Our Ref: AL/21/21/NMA

Non material amendment following grant of AL/116/18/PL for changes to fenestration from the approved plans and changes to the Landscaping plan previously approved

Land West Of Fontwell Avenue Eastergate PO20 3RU

TITLE  
**PROPOSED  
ELEVATIONS**

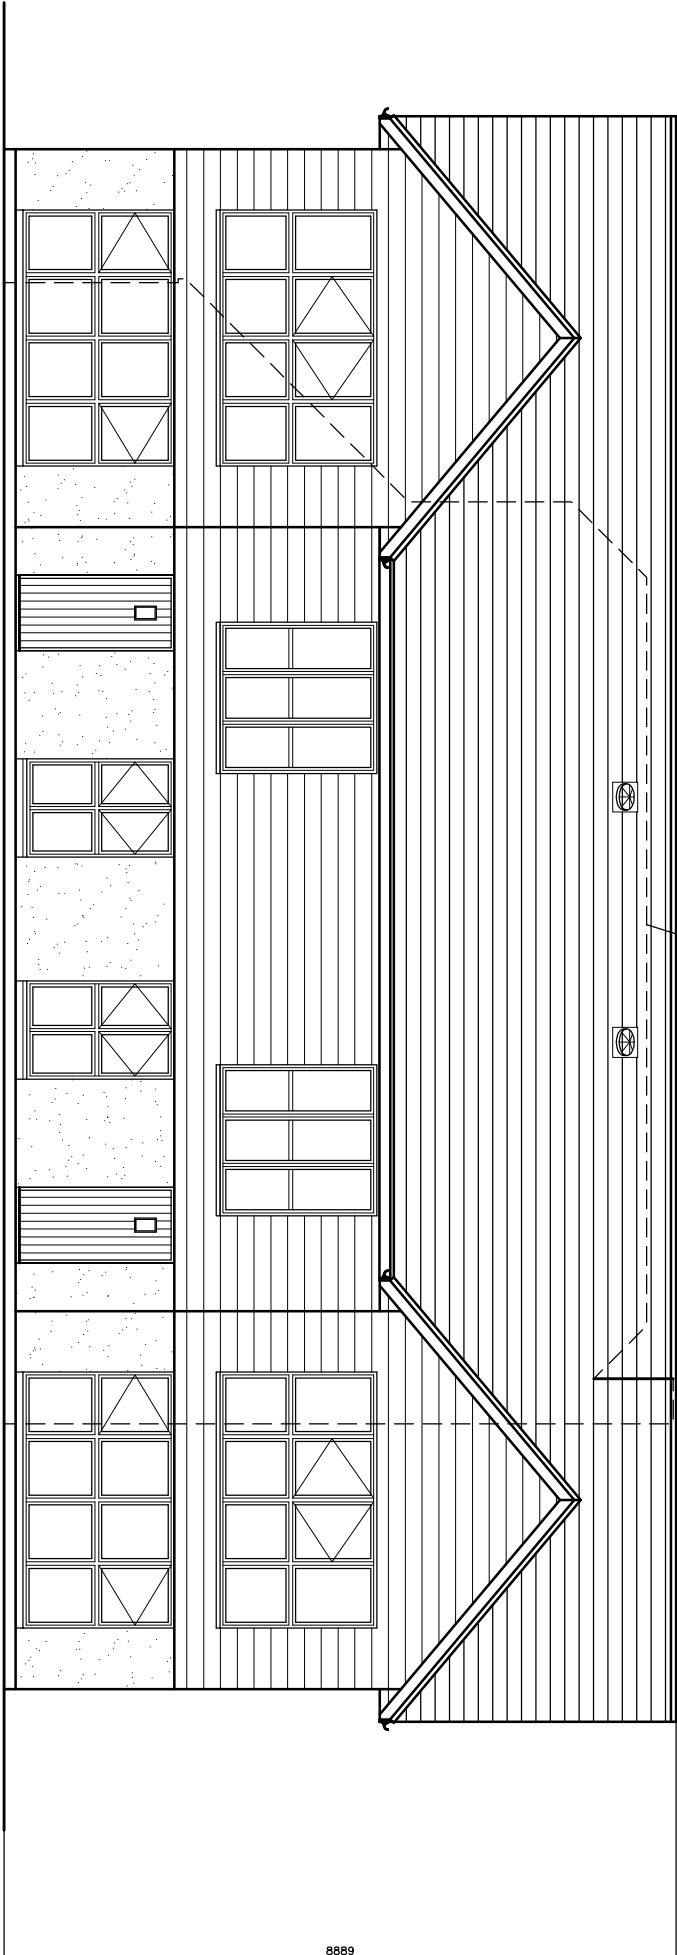
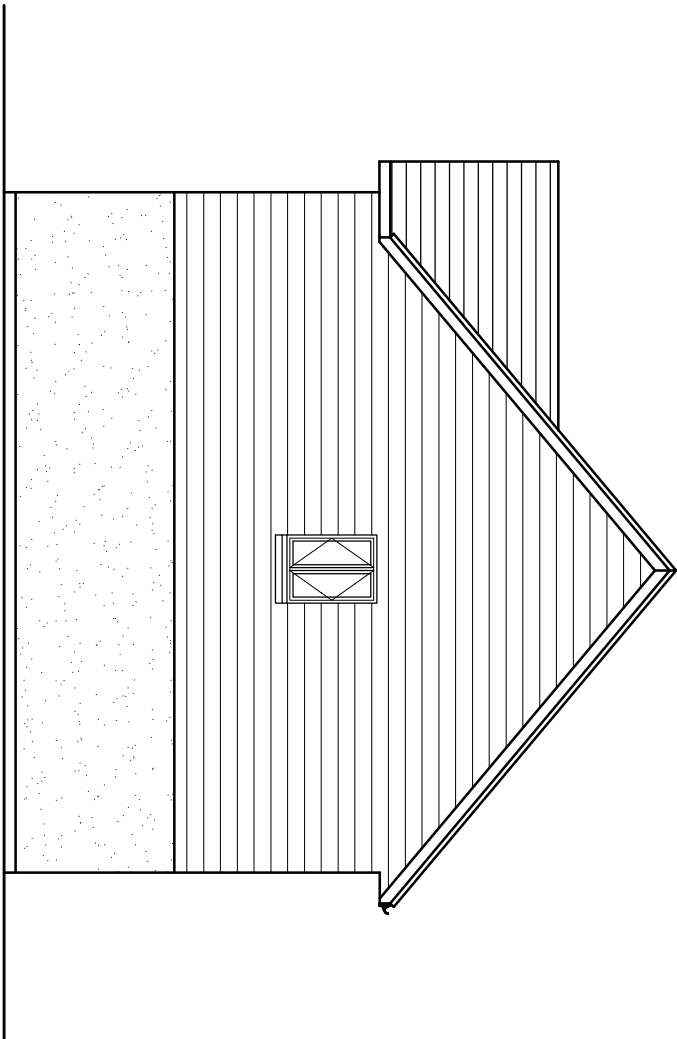
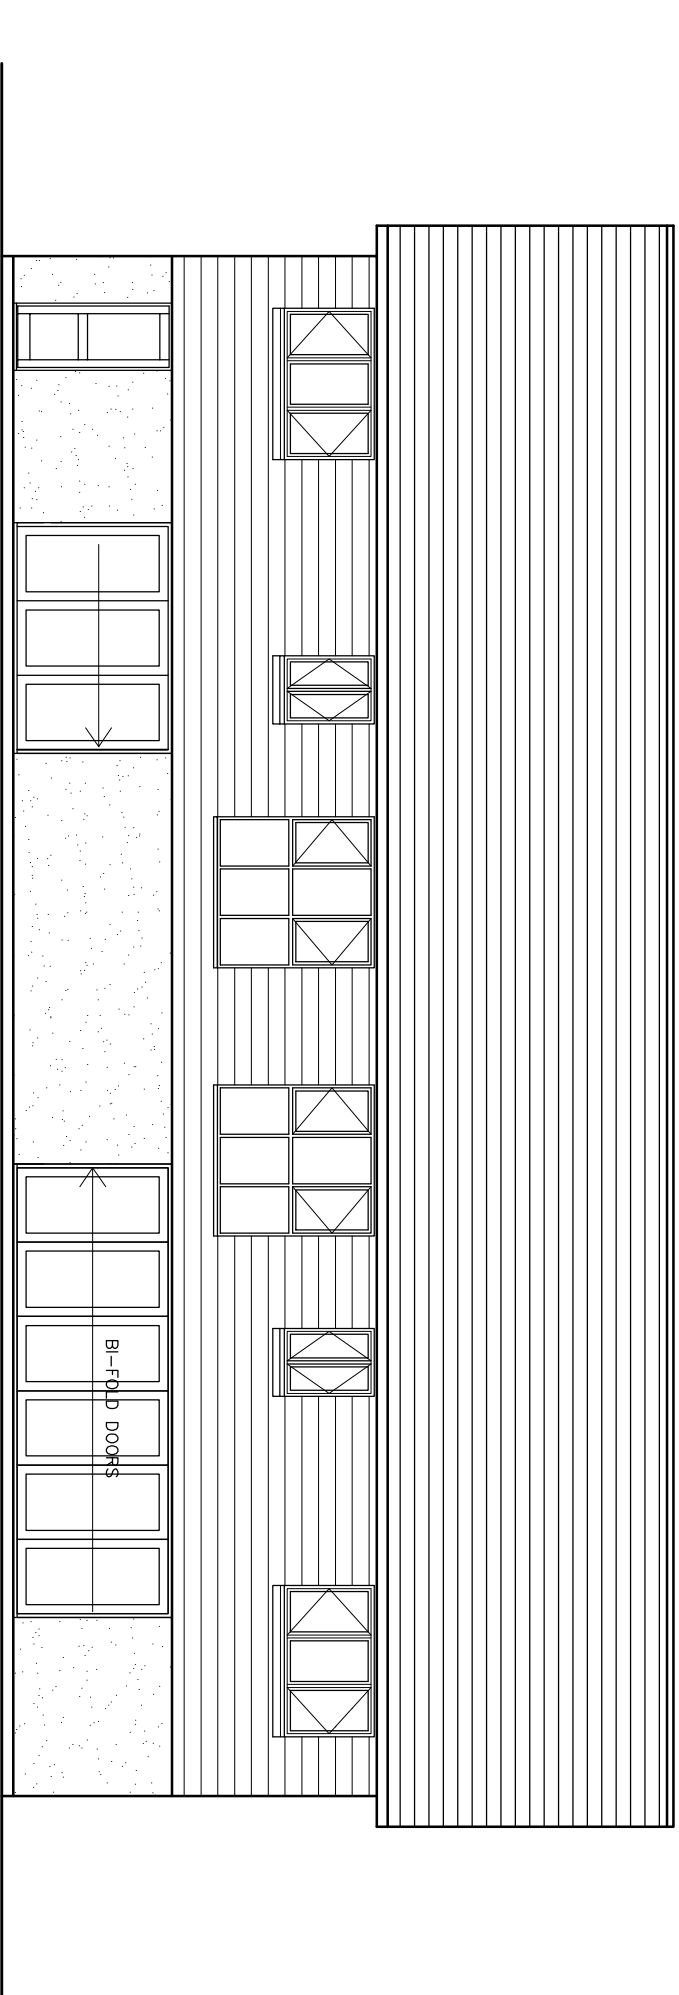
- Add a 150mm step with small kerb edging to the hardstanding at side of each house. I also understand that the rear patio is to slope from that step down to the rear of the house;
- Add a new side door on the SW flank elevation;
- Alter the design of the two doors on the rear of the house that is closest to the boundary with Westfield House; and
- Change the ground floor layout adding a utility room within the approved kitchen space.

It is considered that the proposed changes to the fenestration and ground floor layout do not materially alter the appearance of the development approved by the planning permission, do not alter the development description, do not conflict with any conditions of the permission, do not breach any planning policy, do not warrant re-consultation and are within the maximum dimension change tolerances.

Proposed Ground Floor Plan 02 Rev H; and
Proposed Elevations X04 Rev G;
